The Planning Inspectorate
Yr Arolygiaeth Gynllunio

SCOPING OPINION:

Proposed High Grove Solar

Case Reference: EN0110010

Drawing Title  
**Figure 2.1 draft Order Limits**

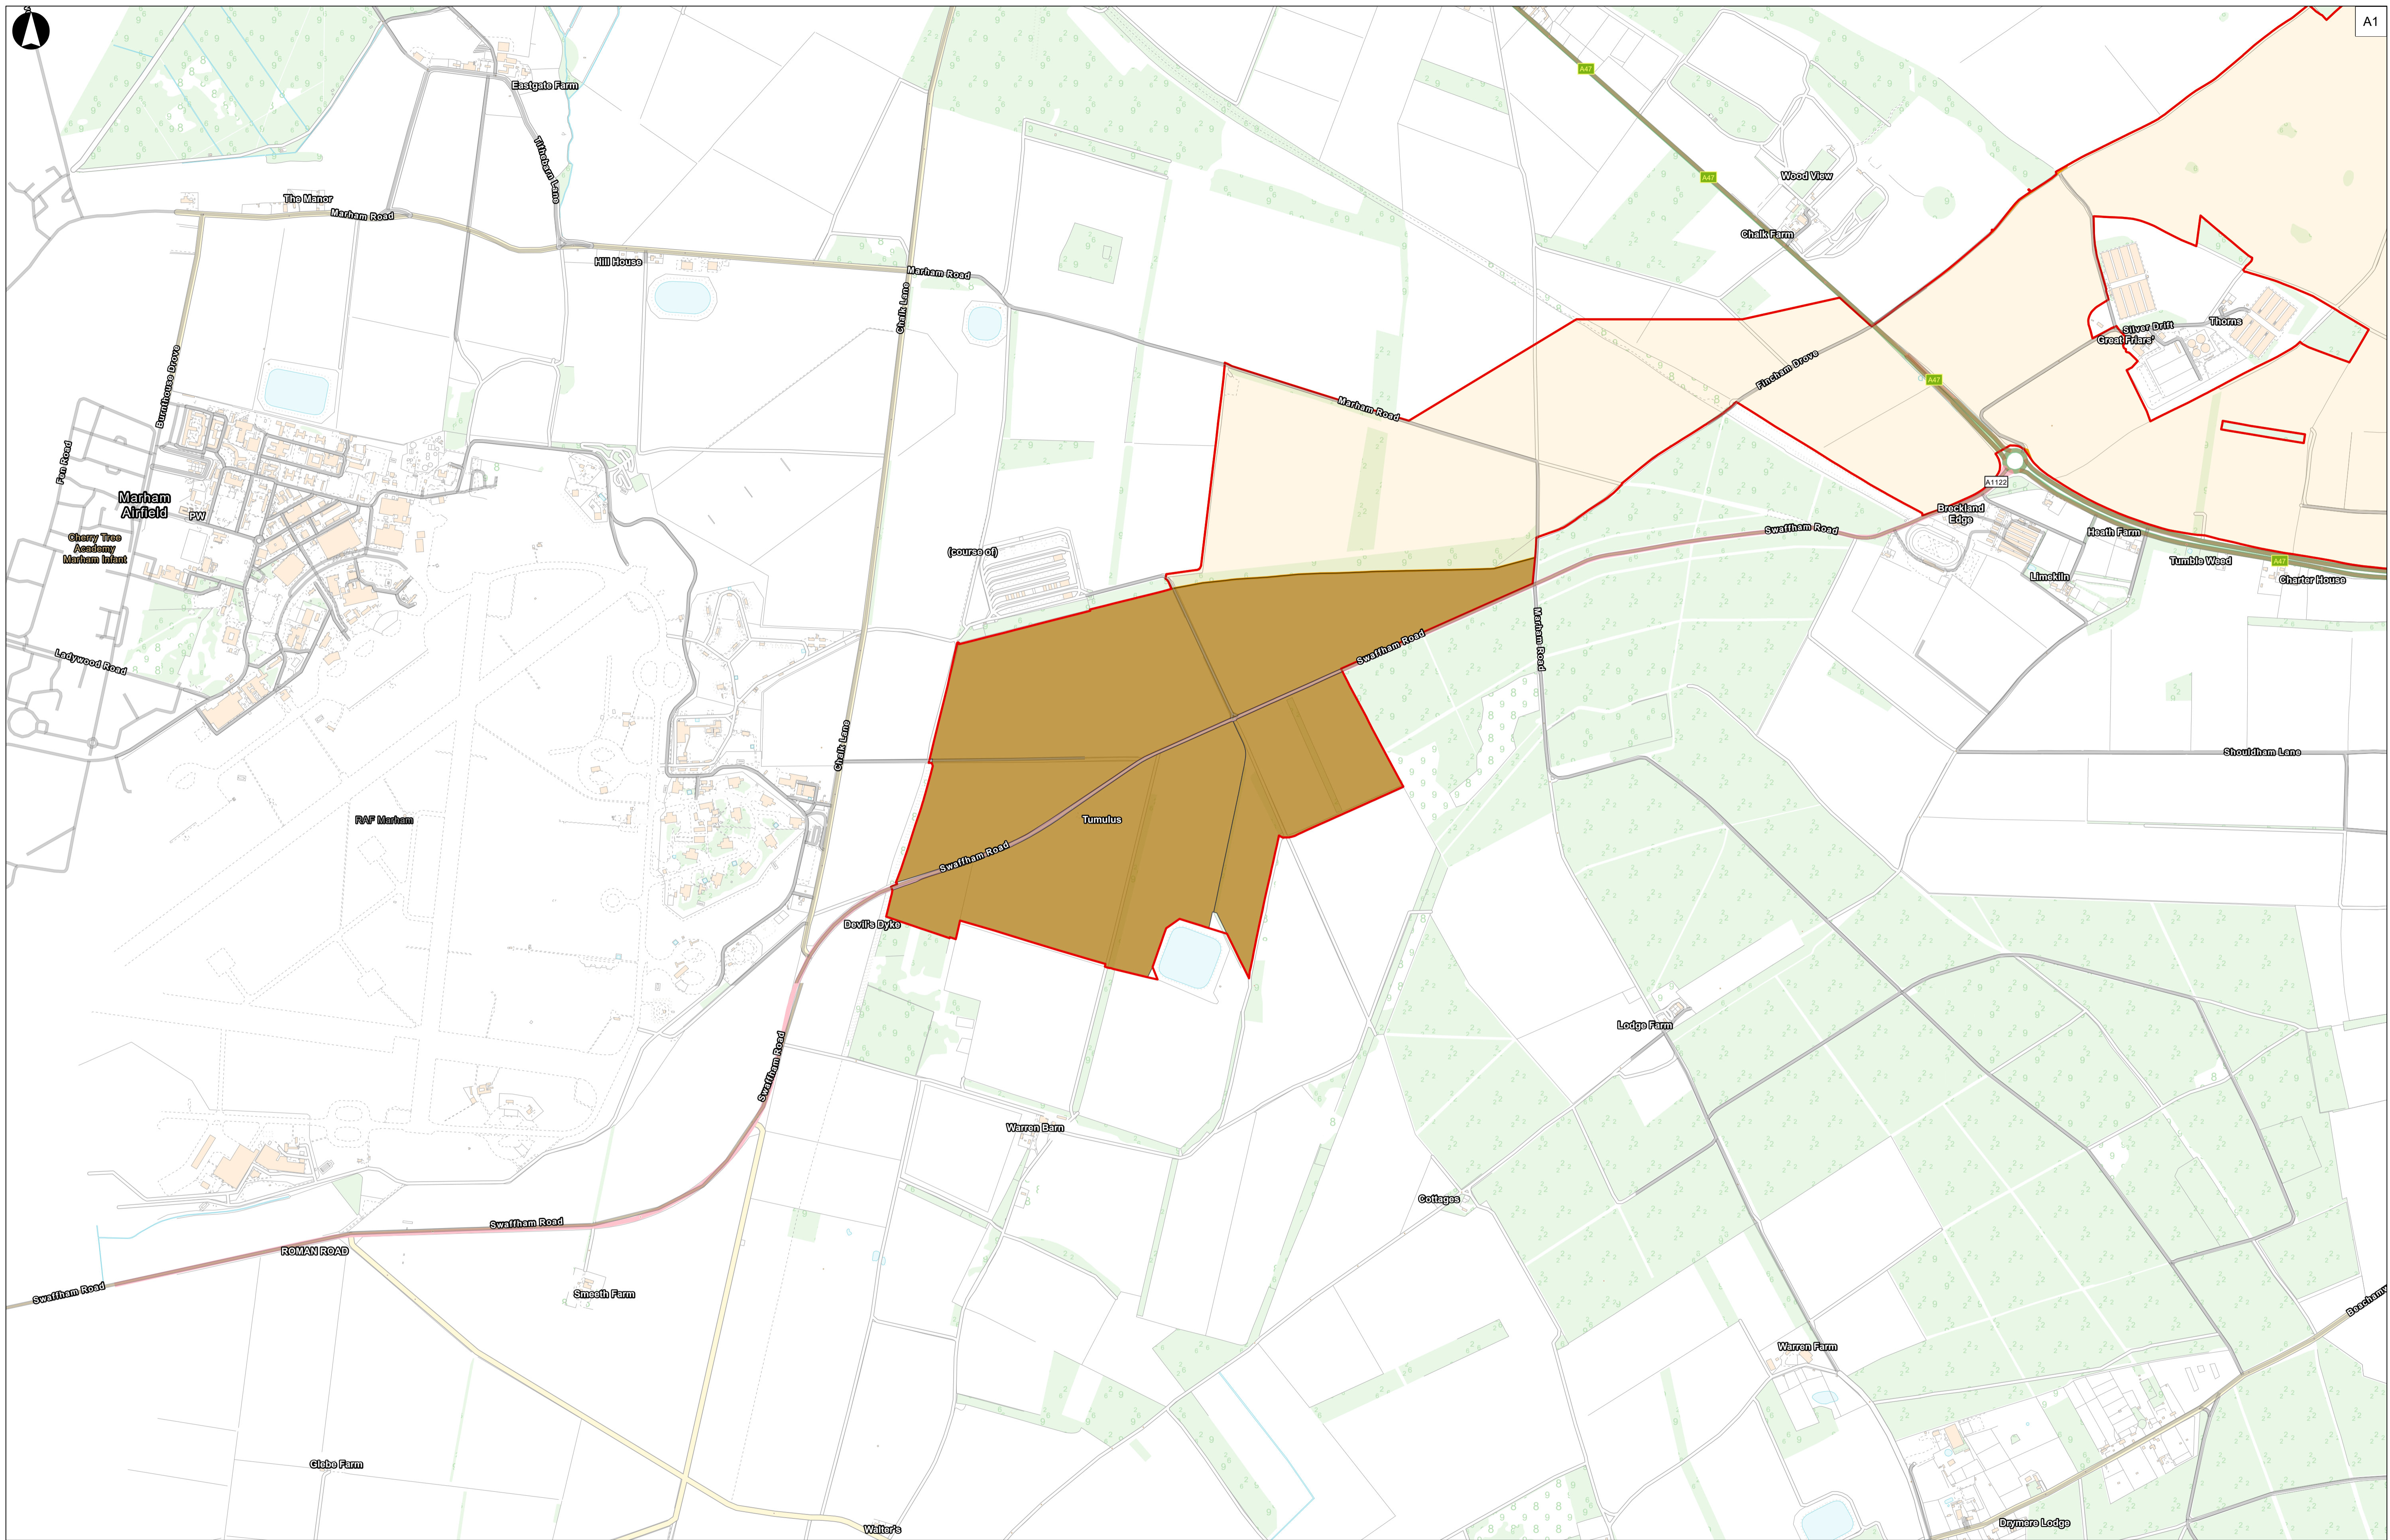
21.9	n/a	Access routes	The ES should describe the proposed site entrance/s and the routes to be used for all vehicular access during construction and operation of the Proposed Development and this information should be clearly presented on supporting plans within the ES. The ES should describe and assess the potential impacts (both positive and negative) associated with any improvements/ changes to the access routes which are either required to facilitate construction of the Proposed Development or are required for restoration purposes on completion of the works. For the assessment of impacts during construction, the ES should explain how the proposed access route(s) relate to sensitive receptors.

Drawing Title  
**Figure 2.2 General Arrangement - Western Panel Area**

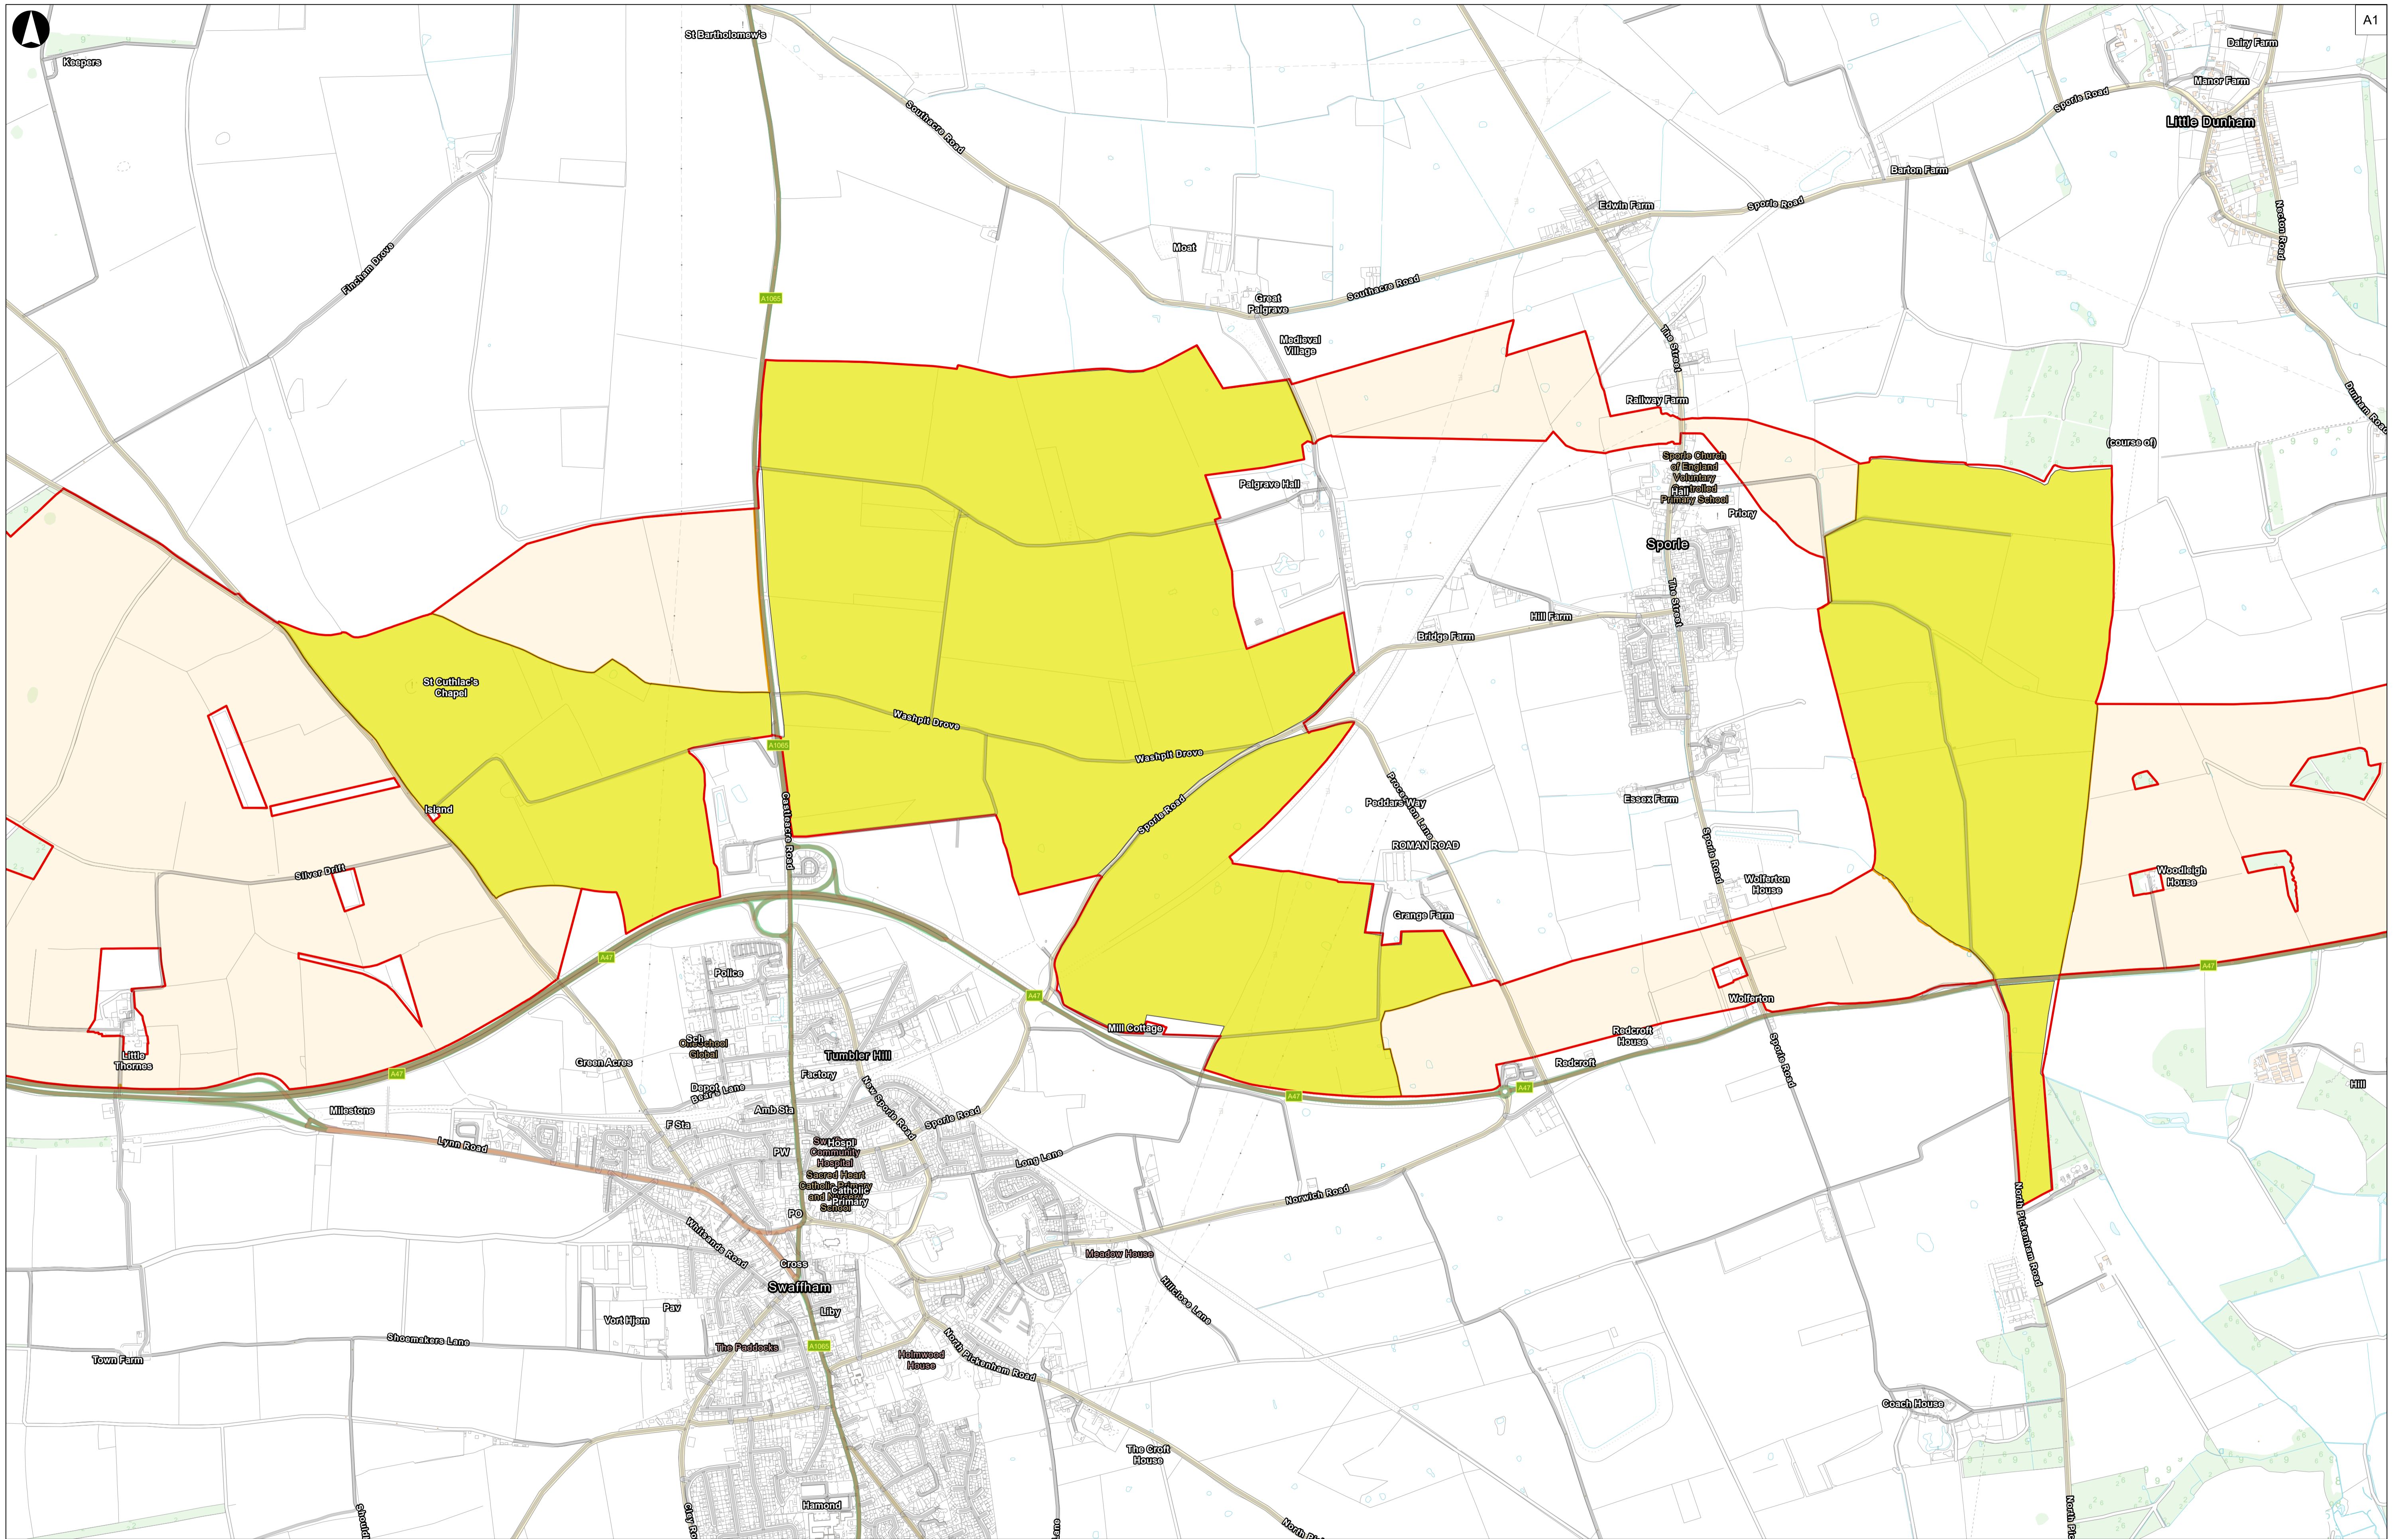
212	Para 2.4.1.2	Panels	<p>The Scoping Report states that there are two options for the proposed panels: static or tracking. The Inspectorate recommends that this decision is made prior to submission of the DCO application. If this is not possible, the ES should identify and assess the worst-case scenario for applicable topics (including Landscape and Visual, Cultural Heritage and Glint and Glare) during operation.</p> <p>The ES should consider the potential for tracker panels to cause noise emissions which could be perceptible to sensitive receptors and should either assess these accordingly</p>
